**RE: Skilled Nursing Facility, 1610 Renaissance Blvd NE
Grading and Drainage Plan
Engineer's Stamp Date 7-17-2015 (File: F16-D017)**

Based upon the information provided in your submittal received 7-16-15, the above referenced is approved for DRB action on the Site Development Plan for Building Permit. It will not be approved for Building Permit until the following comments are addressed:

DRAWN BY
DY
DATE
7/16/15
2014088-GRE
SHEET #
C2
JOB #
2014088

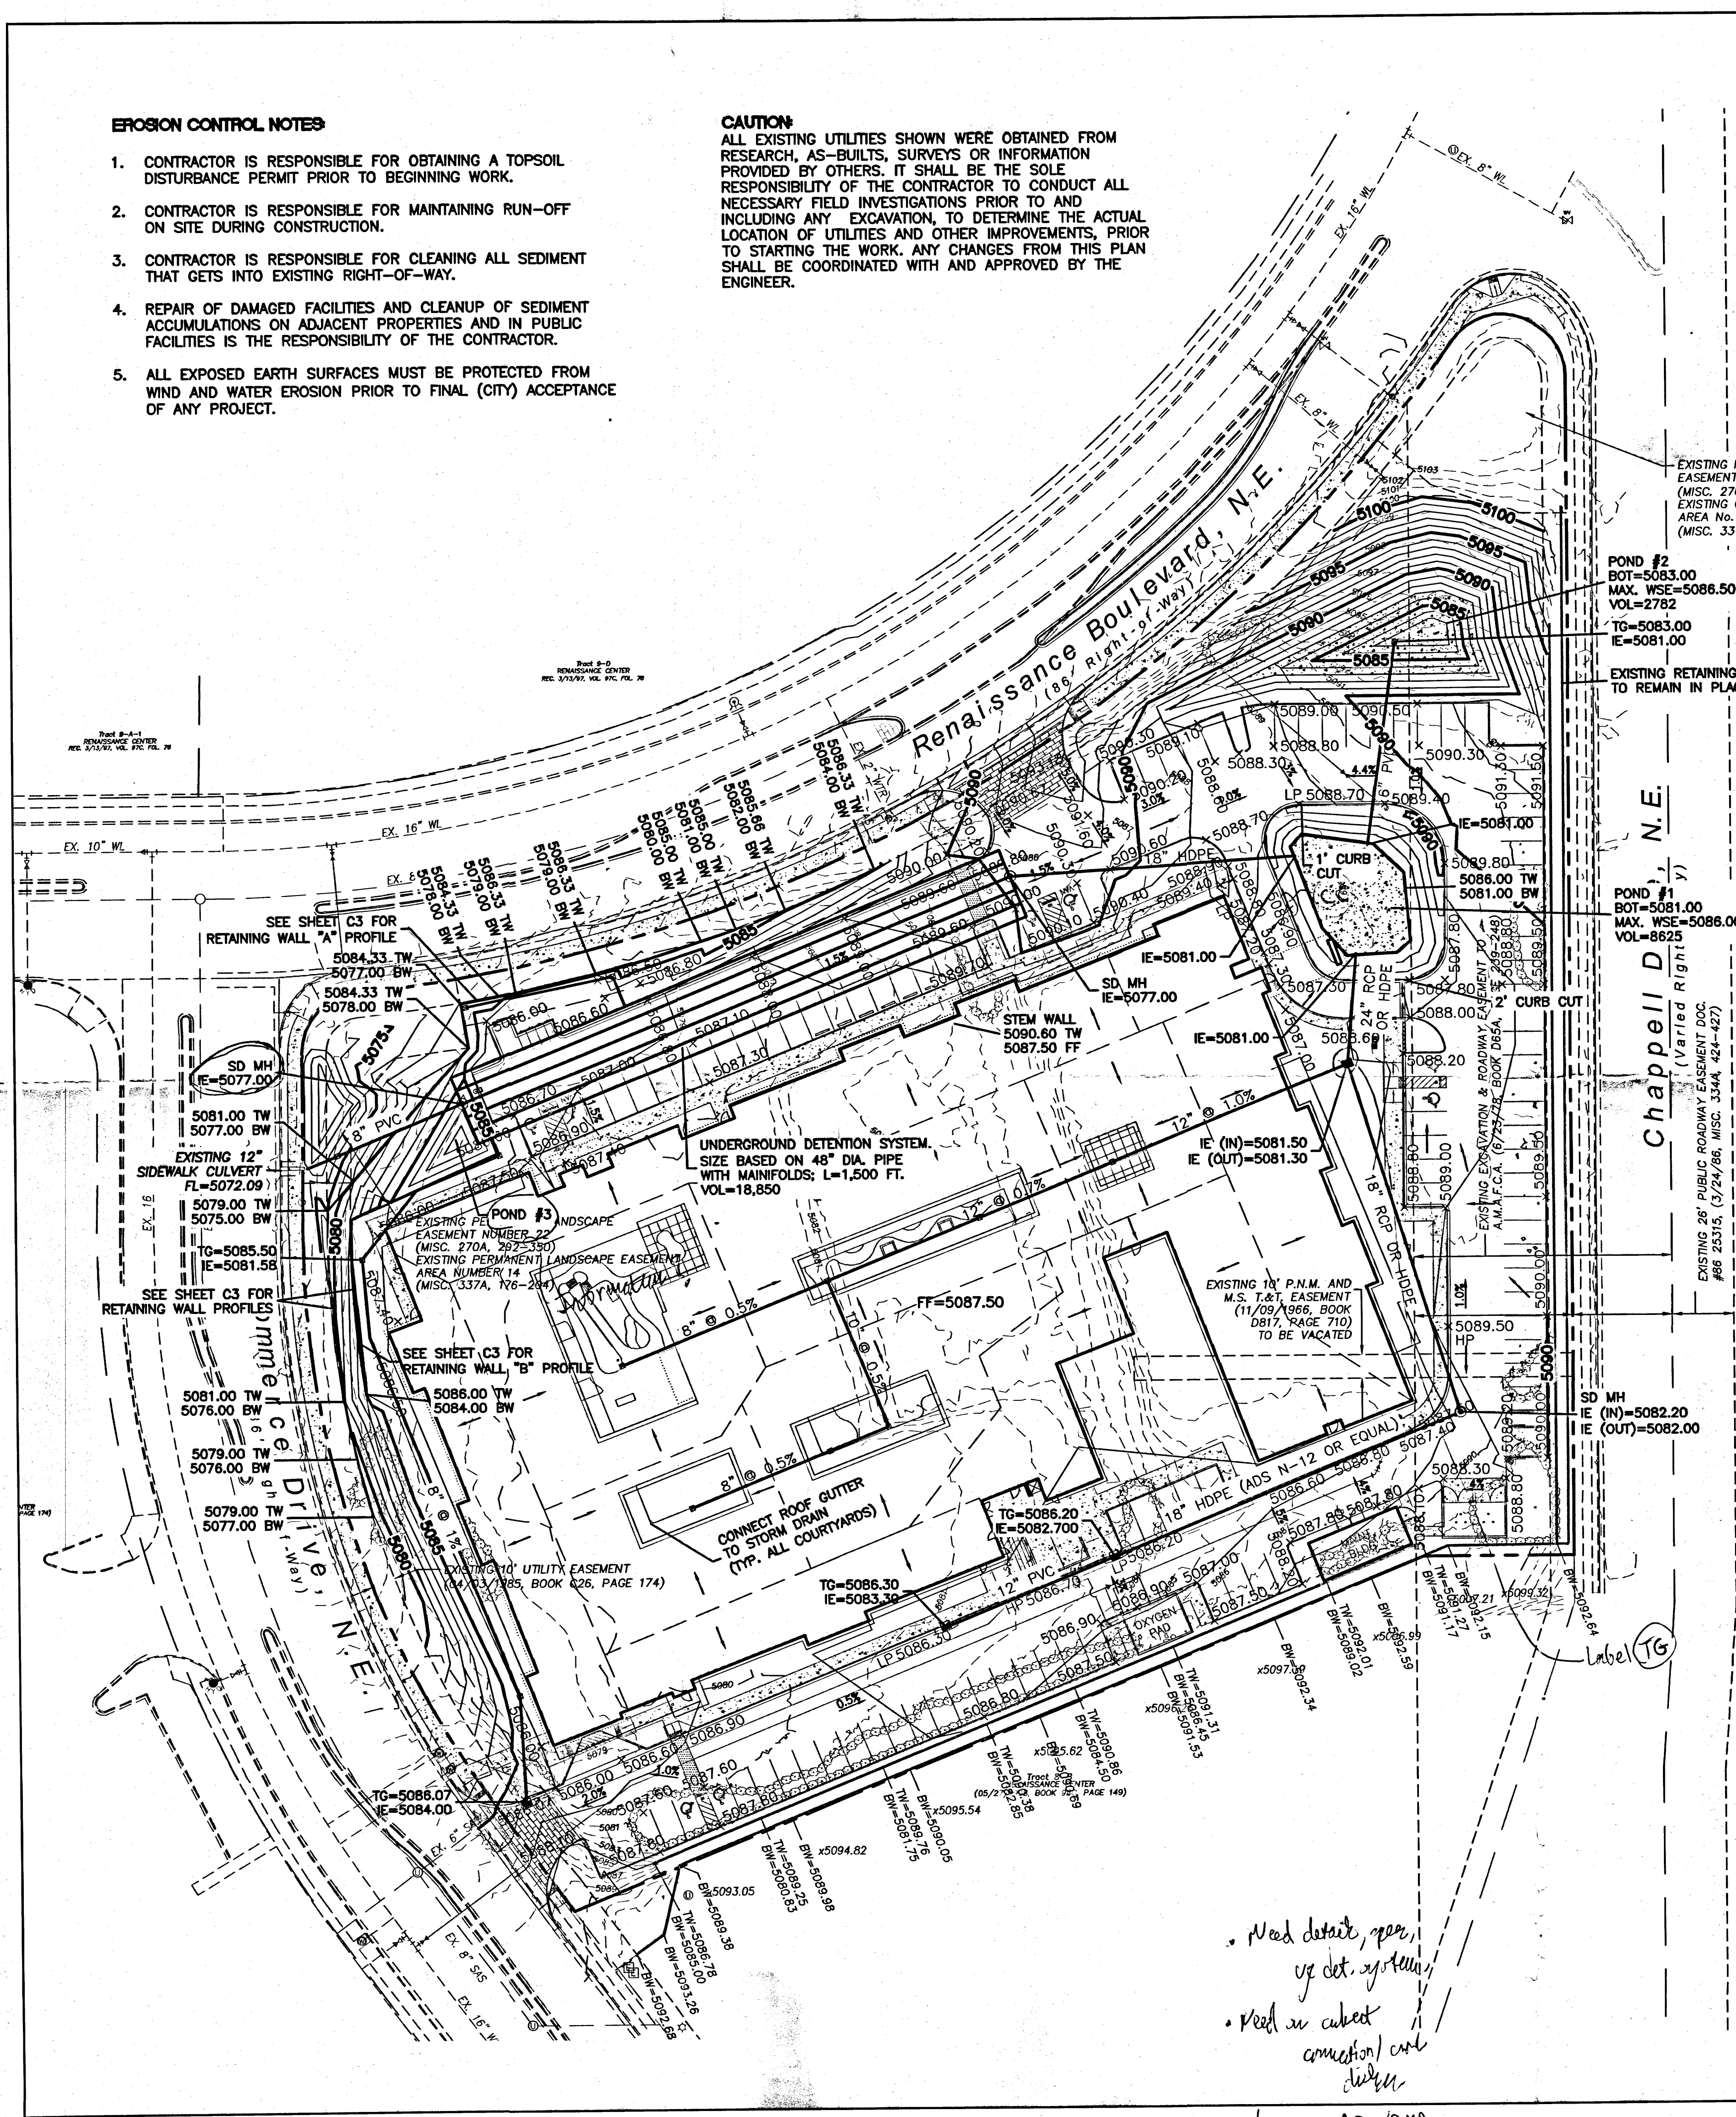
- 2) Label existing spot elevations, and label existing contours on Chappell Drive and on Commerce Drive. Especially show the existing curb elevations at the access points. Take ADA access across the accessways into account.

- 3) Pond 3 is called out on two opposing locations on the grading and drainage plan versus the basin map. This pond appears to be too close to the building on the actual grading plan. No information for it is shown. Was it meant to keep this pond or eliminate it? Revise contours accordingly.

- 4) Hatching appears to show concrete bottoms for Ponds 1 and 2. Provide details as applicable.
- 5) For **all** proposed storm drains, show the flow, slope, and capacity computations. Also, show capacity computations for the proposed inlets.

- 6) There is a spot elevation of 5086.90 that looks like it is at a low spot west of Pond 1. Provide curb cut at the low spot. Provide more spot elevations to show drainage around the curb within this area.

- 7) More detail is needed for the underground detention system. Also, given that these proposed 48" pipes are shown to be flat, how will they be maintained since sediment will easily build up within these pipes? Show details of how the manholes are connected into each end of the system. It appears that there is limited access to maintain the system. Also, what types of pipes are being used?

- 8) A detail is needed for the connection of the 8" pipe into the existing sidewalk culvert. At the connection to the existing culvert, label the proposed discharge flow.
- 9) The land treatment percentages for both Basins C3 and D1 look incorrect since they appear to have a much higher percentage of impervious area than what is shown in the computations.

- 10) Between the discharge to the culvert and the discharge from Basin D1, demonstrate that the site does not discharge more than the allowable discharge of 0.1cfs/acre.

- 11) Label top of grate elevation for the inlet south of Pond 1. List invert and grate elevations for the 8-inch to 12-inch sized pipe through the center of the building.
- 12) In the legend, distinguish between existing and new TW and BW elevations. Provide new wall details as applicable.

- 13) For volume computations, demonstrate that the site discharges 90% of the design storage volume within 6 hours. Use of the 100-year 24-hour storm volumes and distributions will be required for higher times of concentration per the storm drainage ordinance.
